Our Ref: P/69/19/HH

**Town & Country Planning Act 1990 (as amended)
Town & Country Planning (Development Management Procedure) (England) Order 2015
Application for Planning Permission for Works or Extension to a Dwelling**

Development Removal of boundary wall and erection of boundary fence at front of property.

Location 42 The Causeway Pagham

block plan

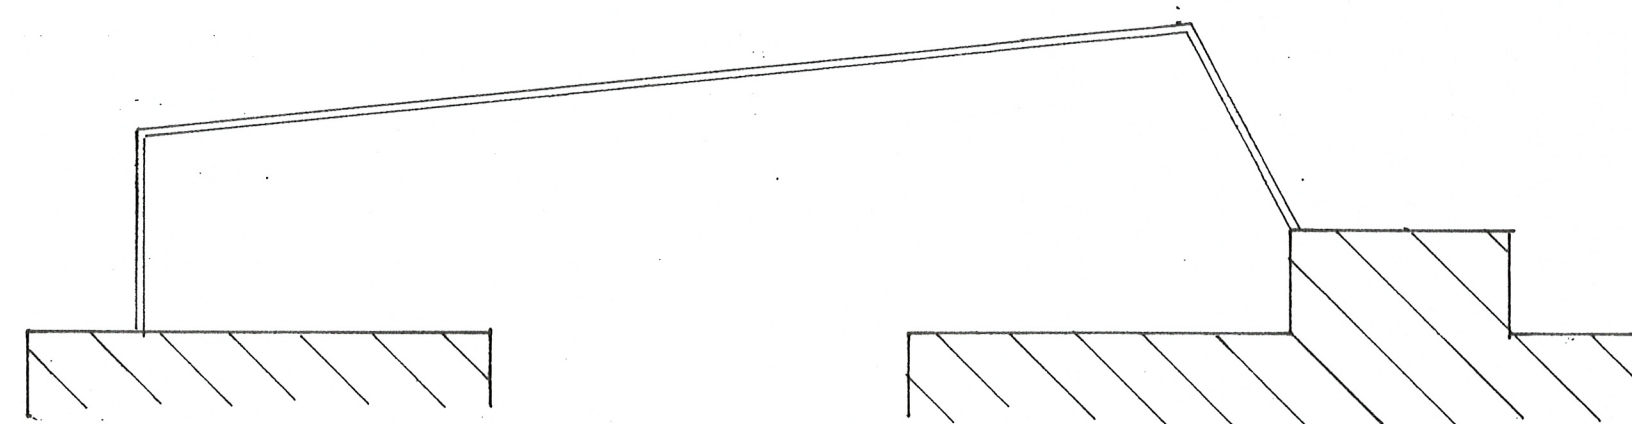
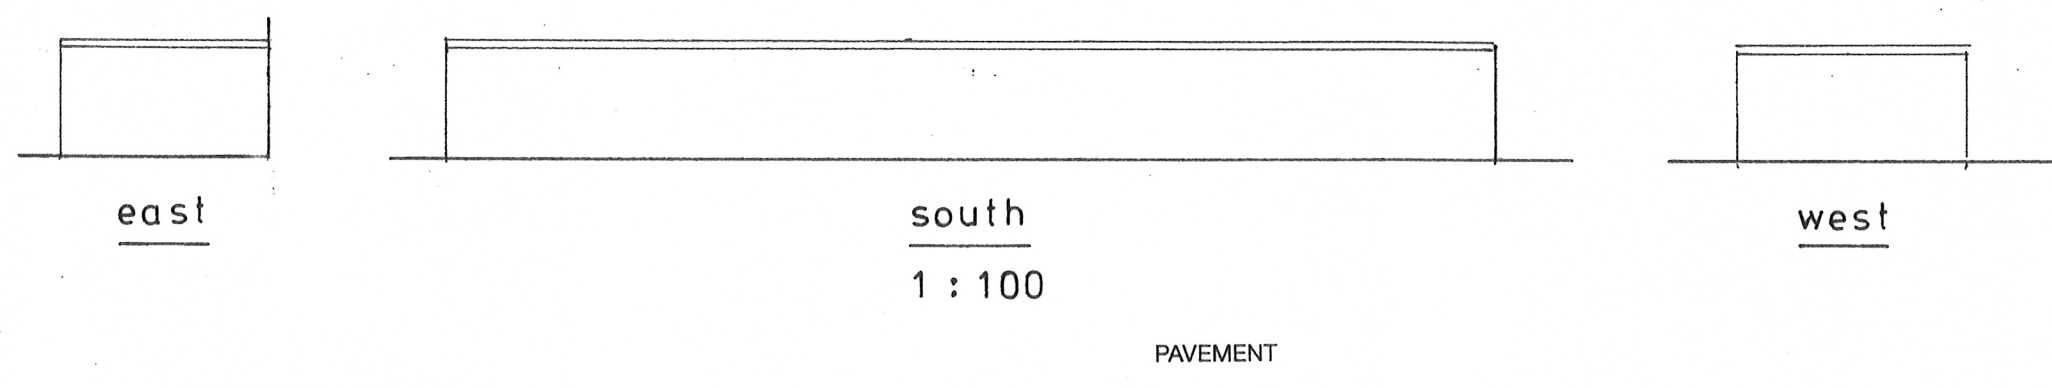
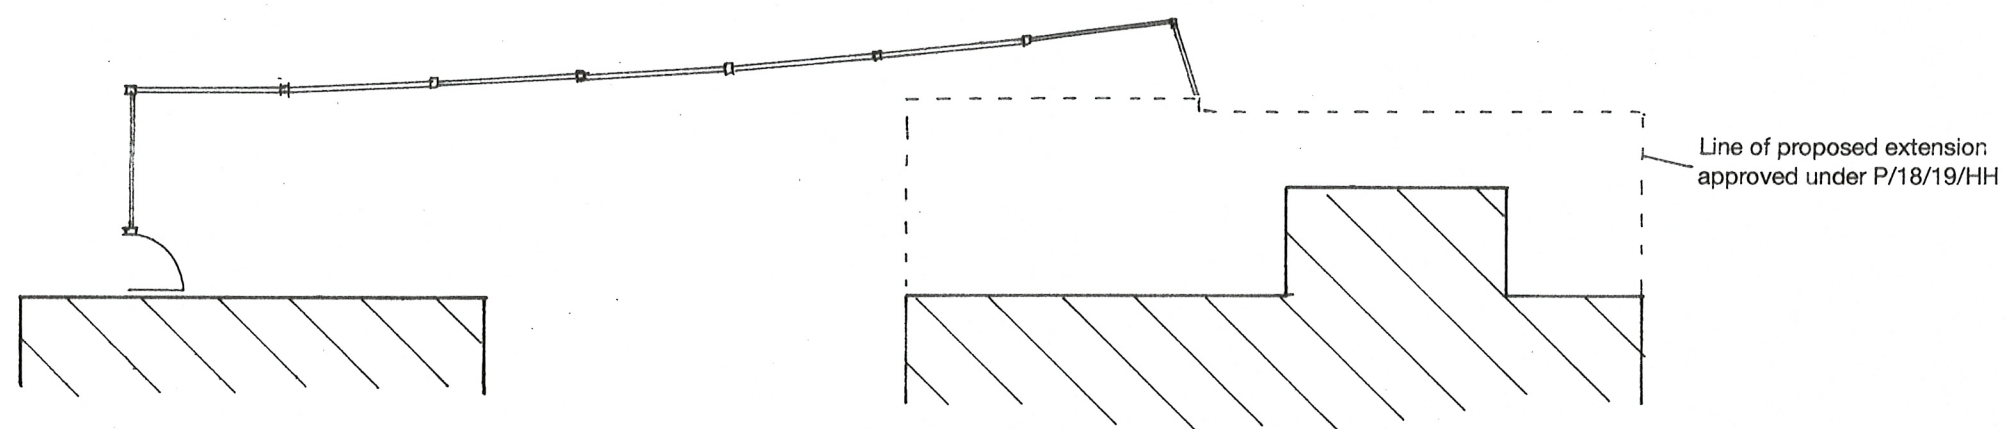
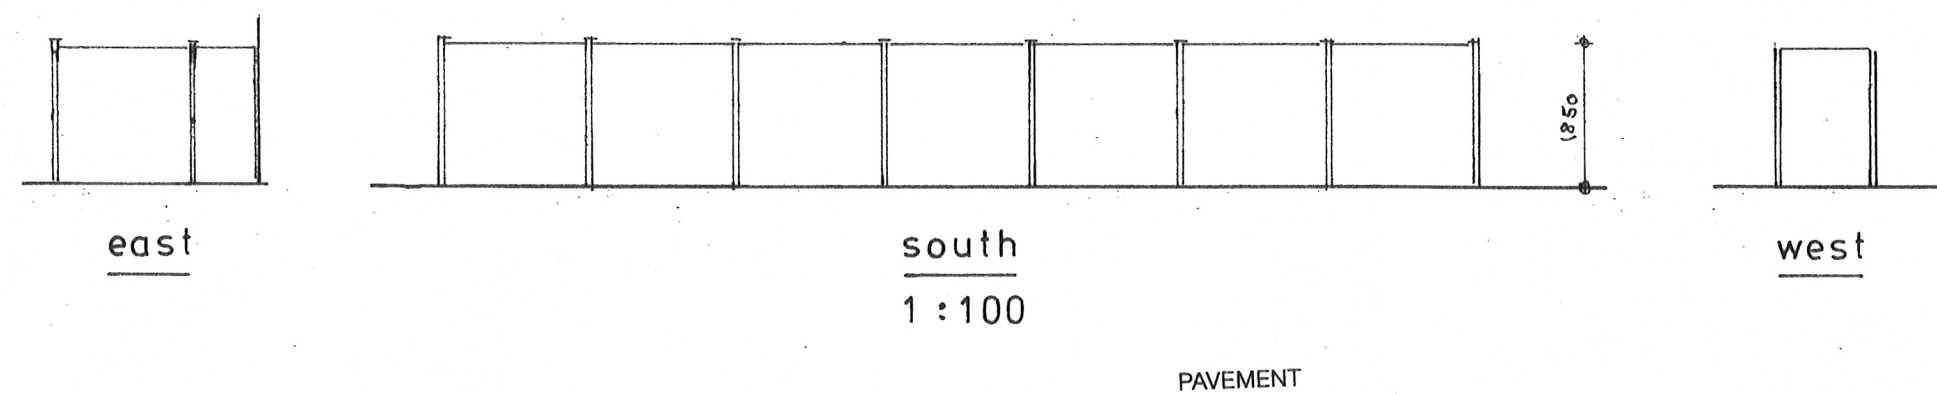
Block Plan

Please submit 1 electronic or 3 paper copies of an amended block/site plan at a scale of 1:500 or 1:200 clearly showing the dimensions of the proposed fence to boundaries. Further details of what must be included on the plan can be found in the National Validation Requirements.

Please provide details of the proposed boundary fence, including dimensions. This can be photos or drawings.
